9 Portland St.

Renovations

Preble St. Resources

**From:** Marge Schmuckal  
**To:** Kandi Talbot  
**Date:** Tue, Apr 29, 2003 11:38 AM  
**Subject:** 9 Portland Street - Preble Resource Center

PSRC 5 portland street portland, maine owner: preble street resource center portland, maine	architect: james sterling, aia 142 high street portland, maine elevations	date: 22 april 03 scale: 1/4" = 1'-0" A-2.1
--	---	--

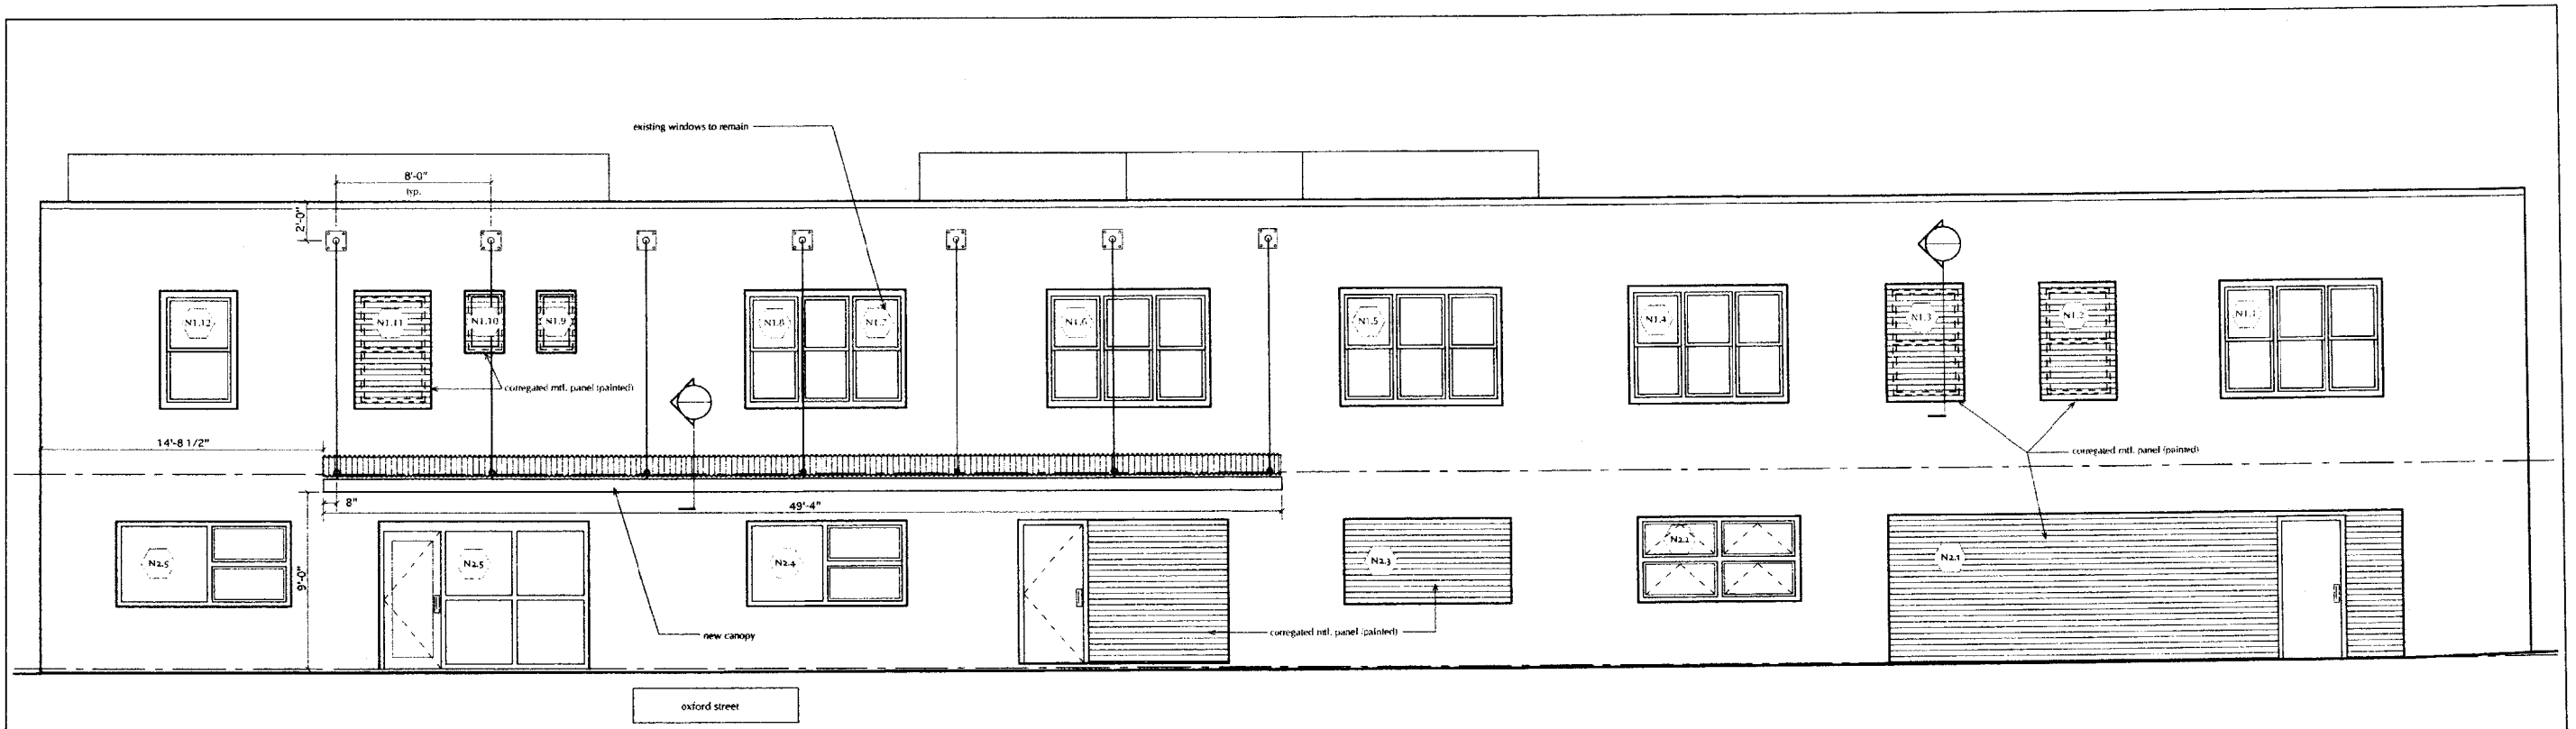
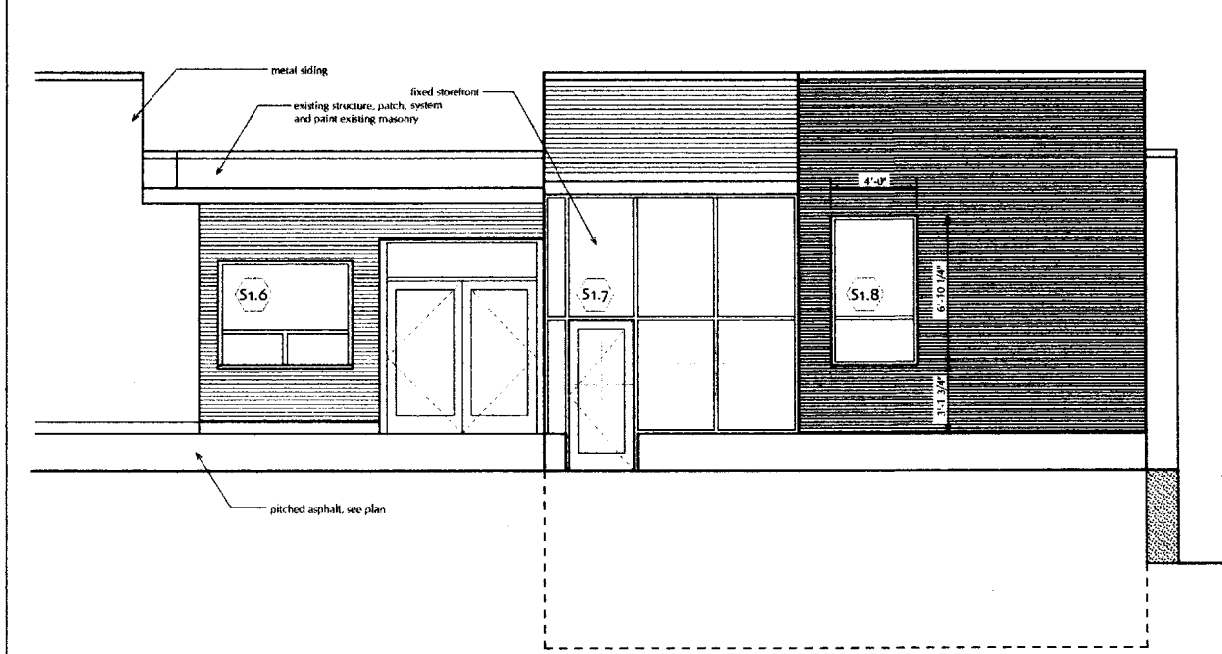
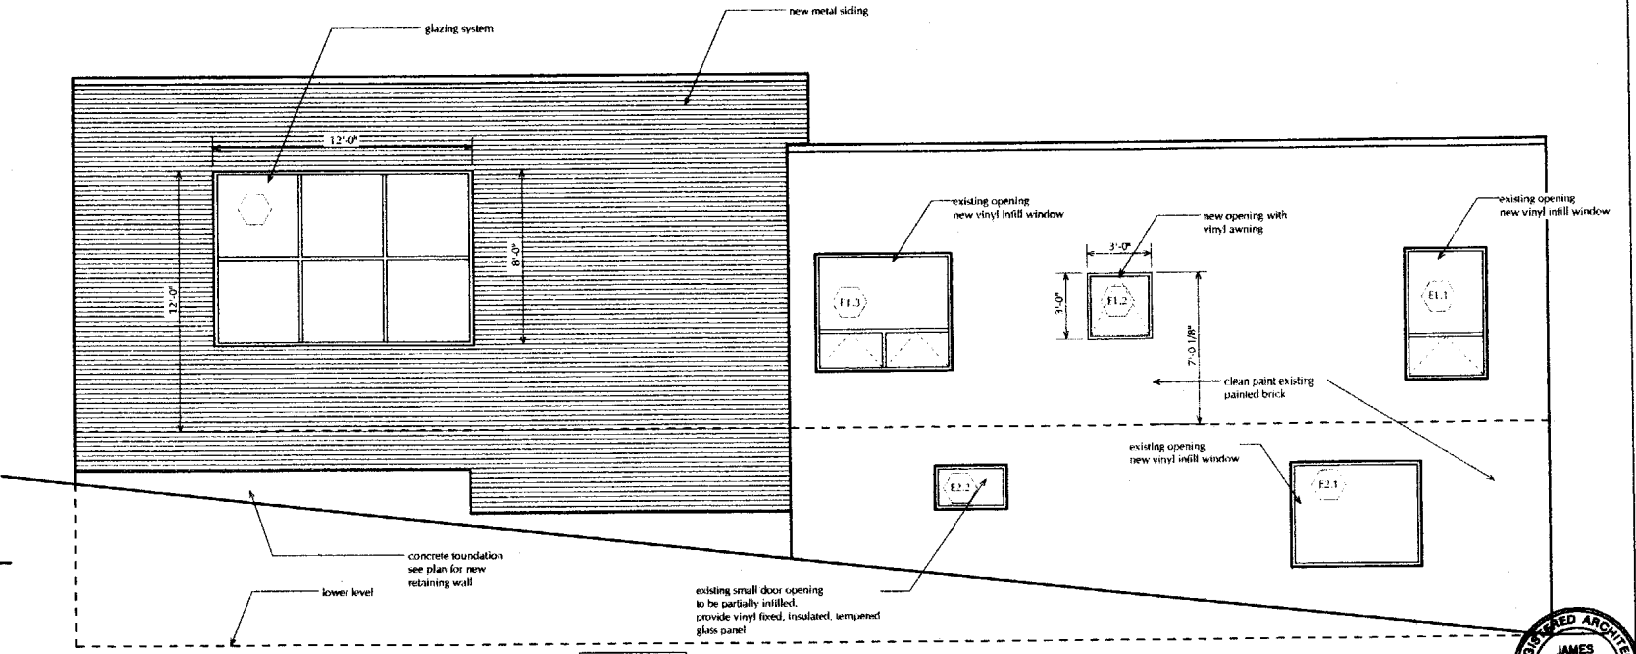
I have reviewed this site plan submittal. There is one zoning violation concerning height. Section 14-220 states: " No new construction of any building shall be less than thirty-five (35) in height within fifty (50) feet of any street frontage except for parking adendant booths or bank remote teller facilites". I am measuring only 22 feet in height.
